From: Neville, Julie <Julie.Neville@lancashire.gov.uk>
Sent: 15 October 2025 11:46
To: Planning
Cc: Walsh, Kathryn
Subject: 3/2025/0606 Eatoughs Farm Fleet Street Lane Ribchester PR3 3XE
Attachments: 3 2025 0606 Overlay.pdf

Reference 3/2025/0606
Location Eatoughs Farm Fleet Street Lane Ribchester PR3 3XE
Proposal Proposed riding arena, stables, store room, hard standing and access

Proposed Stables - Proposed Site Plan

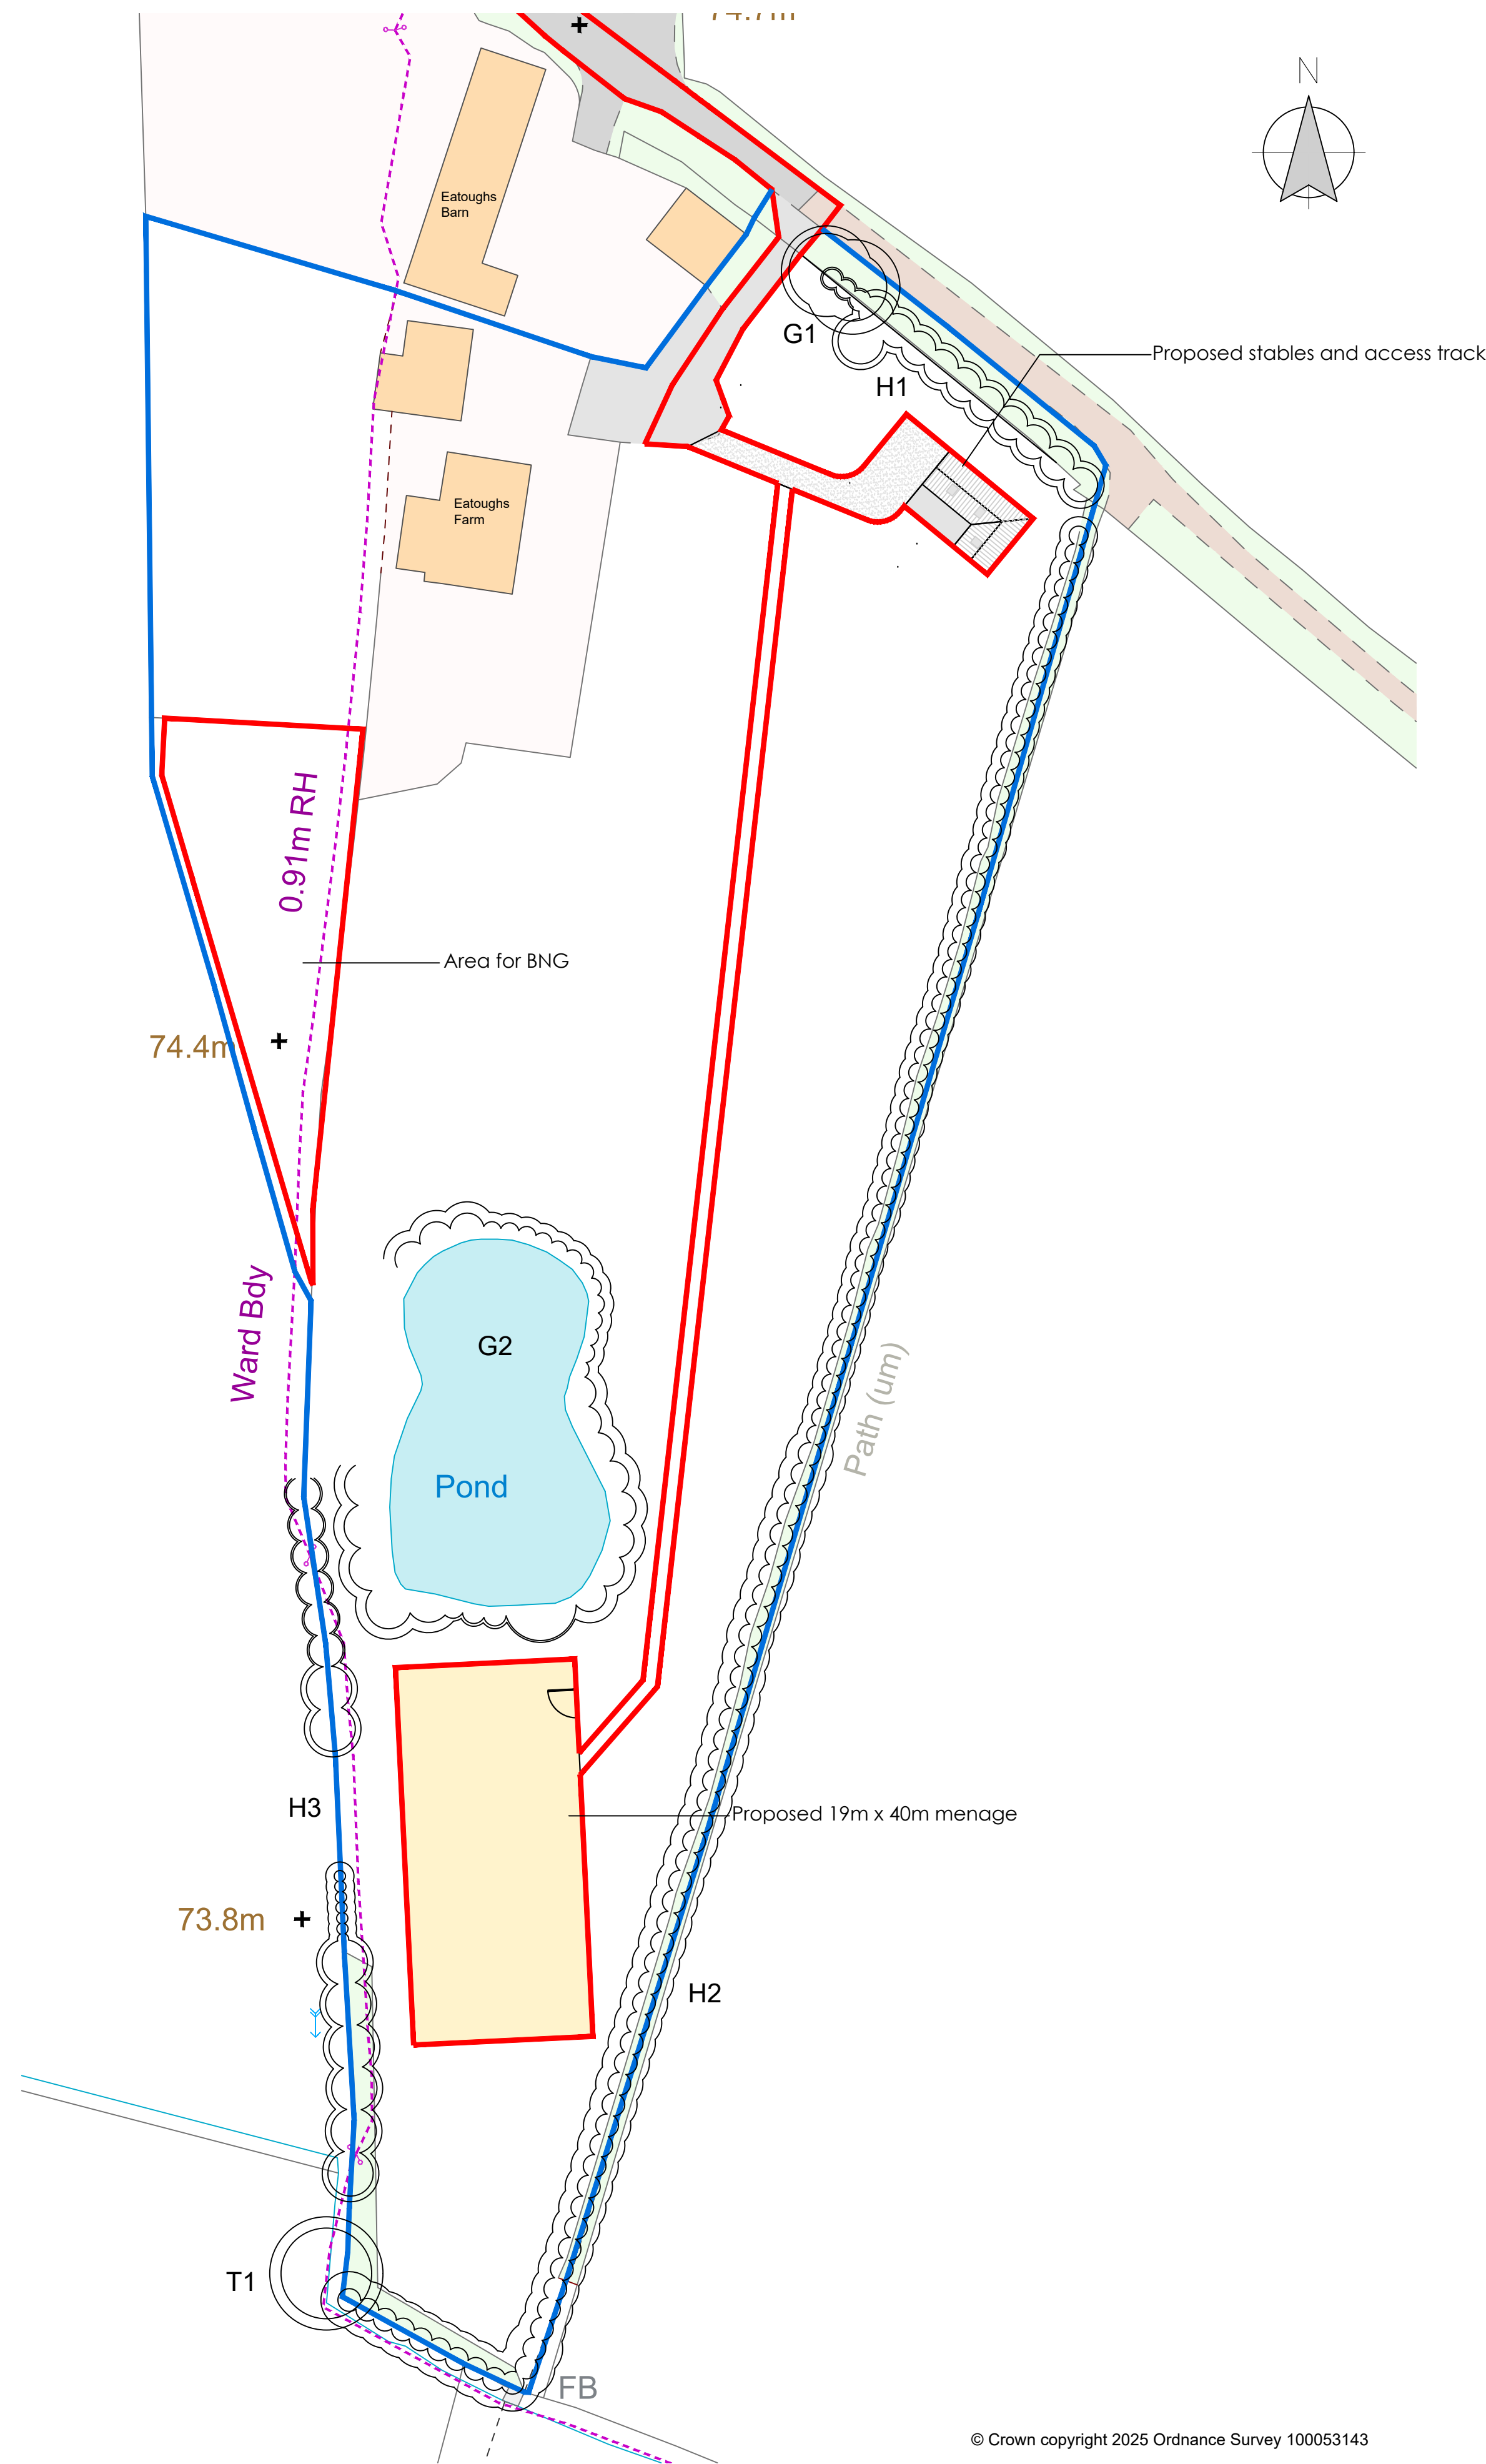
Footpath FP0335035 is recorded through the proposed development accessed along Fleet Street Lane and the agricultural track also recorded as footpath FP0333038 and FP0305037, as shown by the indicative line on the attached overlay.

The location of the proposed menage raises concerns as to the available width remaining for the provision of the footpath. The National Planning Policy Framework 2024 places an obligation on developments to protect and enhance public rights of way and access, including taking opportunities to provide better facilities for users. It is the view of the Public Rights of way Team that the development does not meet this requirement without there being a minimum 2 meters usable width between the menage, greater if electric fencing is to be used and planting along the field boundary.

The granting of planning consent does not entitle the developer to obstruct the Public Right of Way. Therefore, the infringement or obstruction of the footpath would be a criminal offence and one that would be subject to enforcement should it be impeded. To prevent this occurring the right of way should always remain accessible and not used to park or store materials, vehicles or machinery during or proceeding construction.
